NC DEPARTMENT OF  
**HEALTH AND  
HUMAN SERVICES**

Division of Public Health

RE: Food Lion #1622  
1363 N. Raleigh Street  
Angier, NC 27501

This letter acknowledges review of the remodel plan for the above referenced establishment. The plans received on 08/10/2023 application, and specifications including email correspondence are approved with the following conditions and comments:

**1 DELI/BAKERY FIXTURE PLAN**  
A4.01 SCALE: 1/4" = 1'-0"

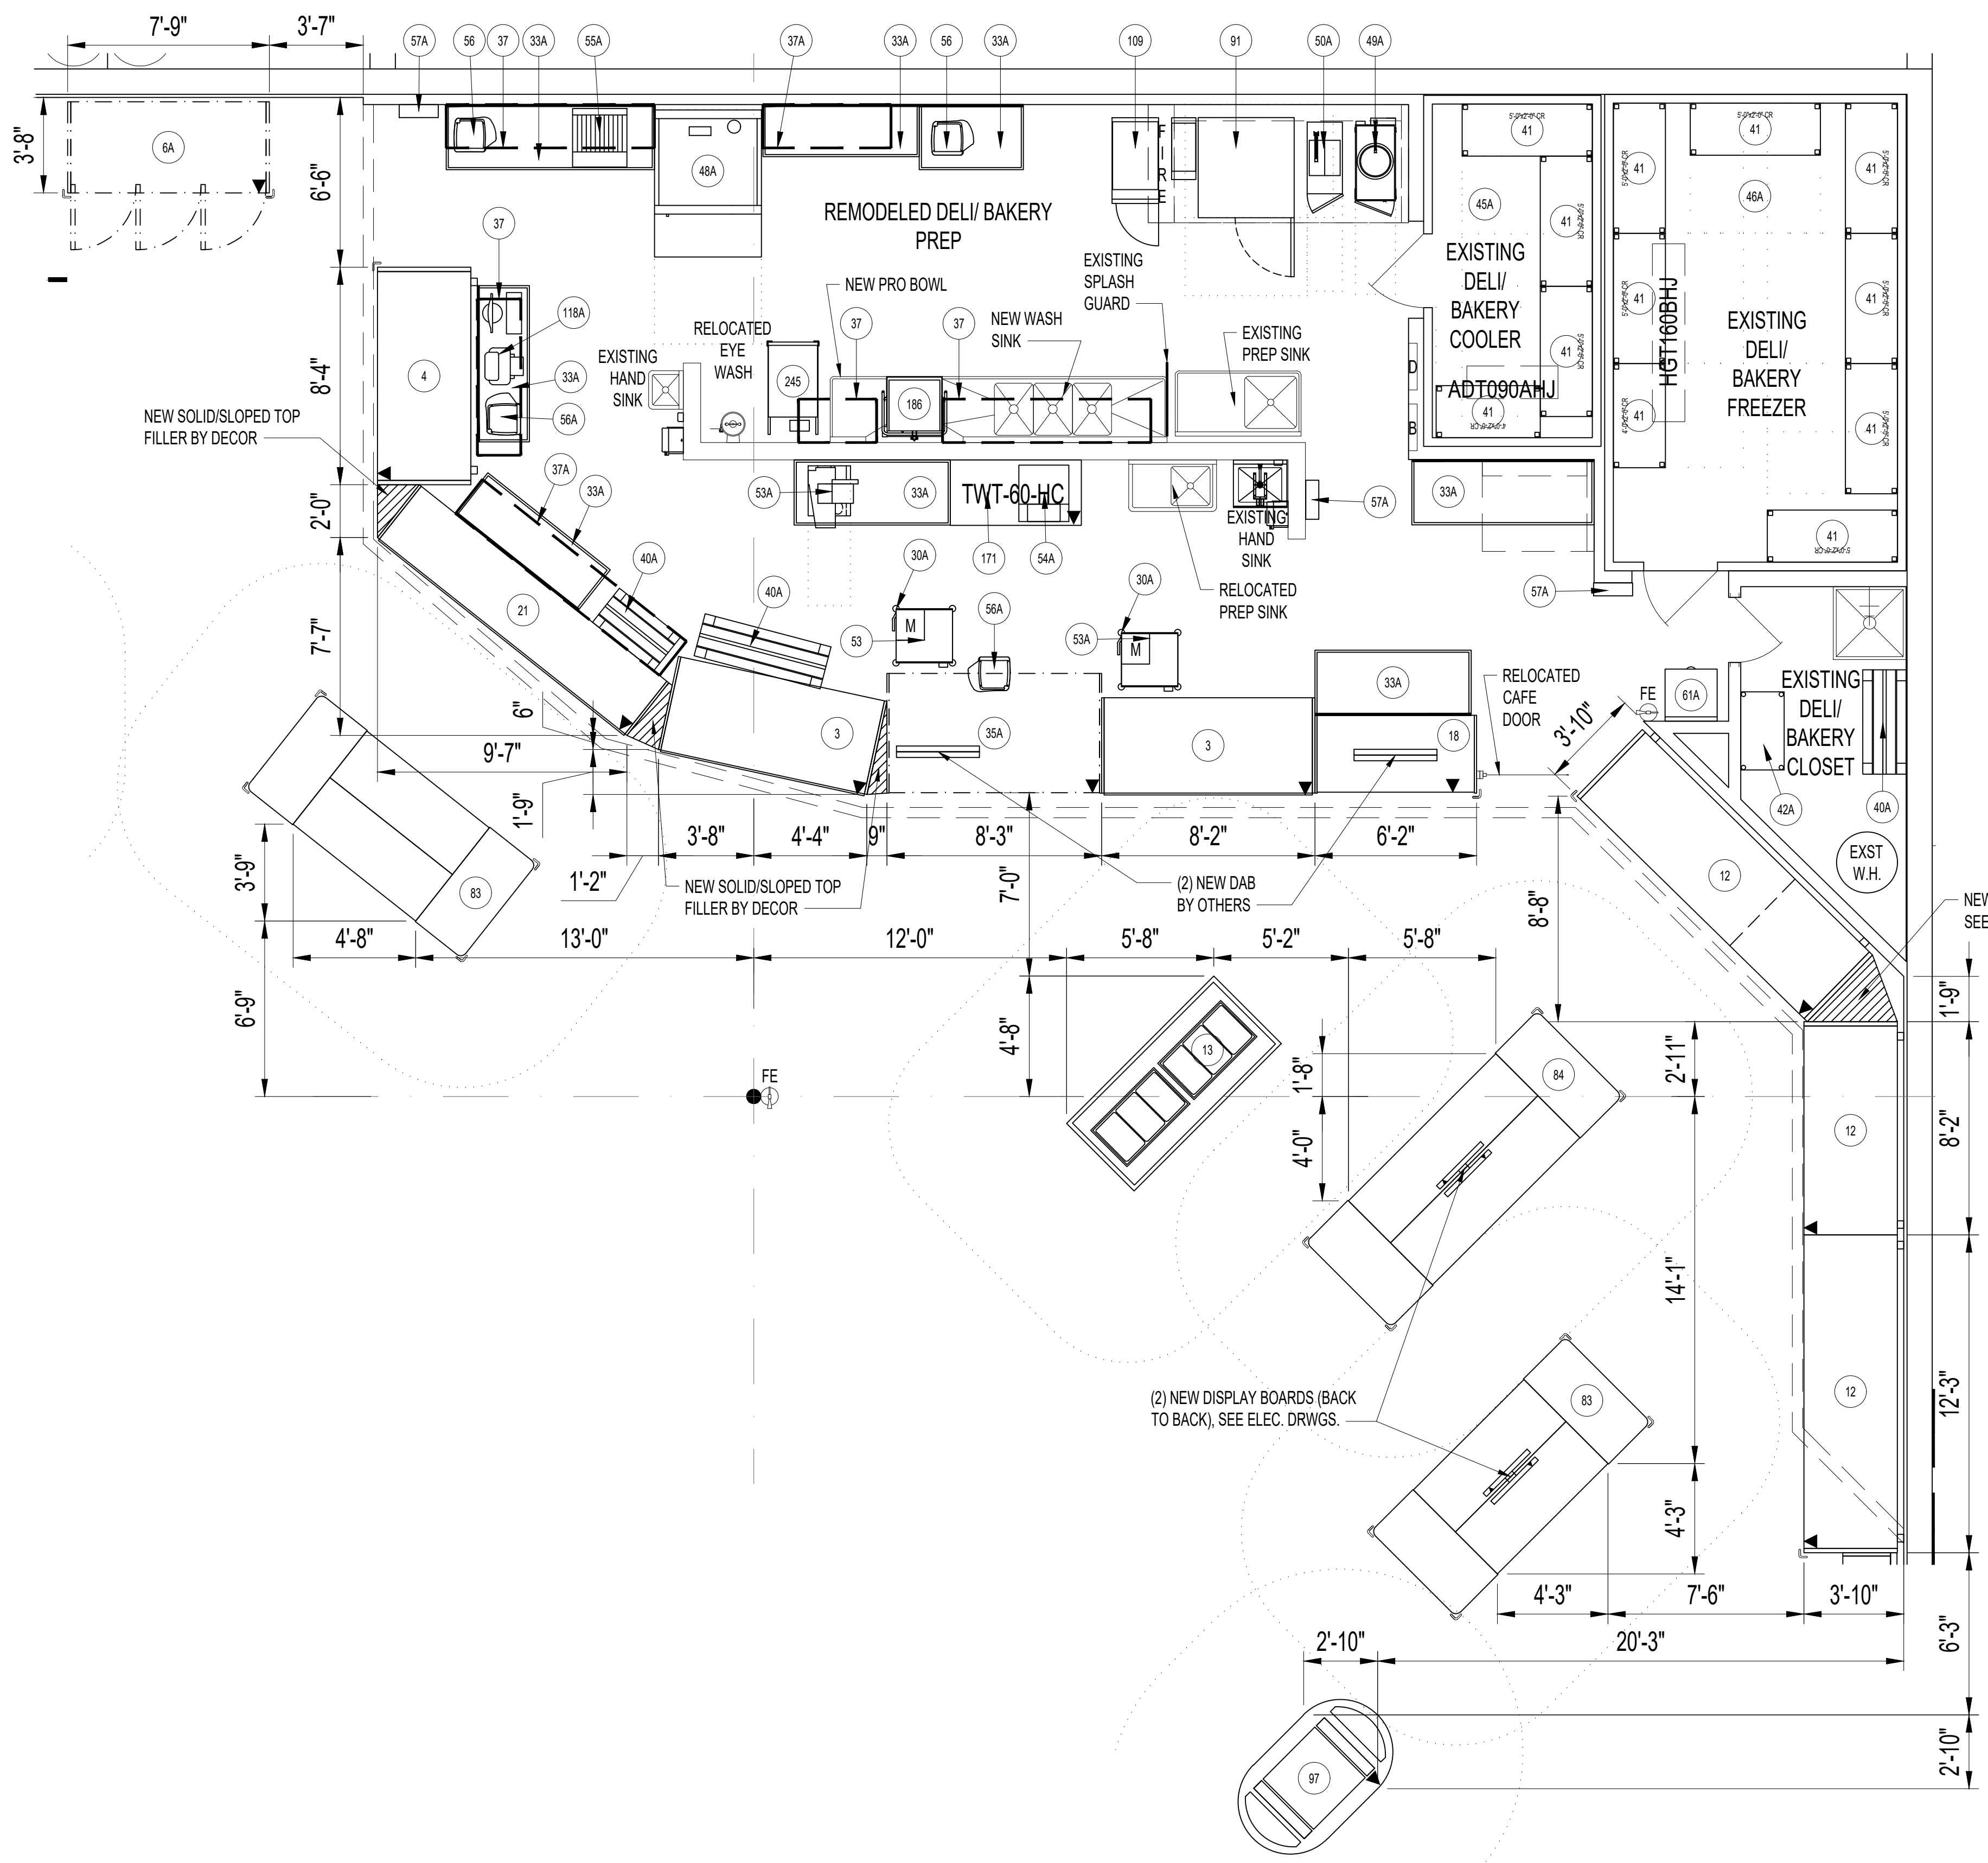
1. The scope of work covers the addition of new equipment in the Deli/Bakery Prep/Sales Areas with the installation of new equipment noted on the scope of work as follows:

- (2) stainless steel tables
- (5) boat racks
- (1) hot deli self-serve case
- (13) cooler racks
- (2) deli self-serve cases
- (1) self-serve bakery
- (2) scales
- (1) combi oven
- (4) cold deli islands

Please note the combi-therm oven (and relocated fryers) will need to be installed under the hood in accordance with the local building code, as well as meeting all requirements listed in the equipment specification sheets.
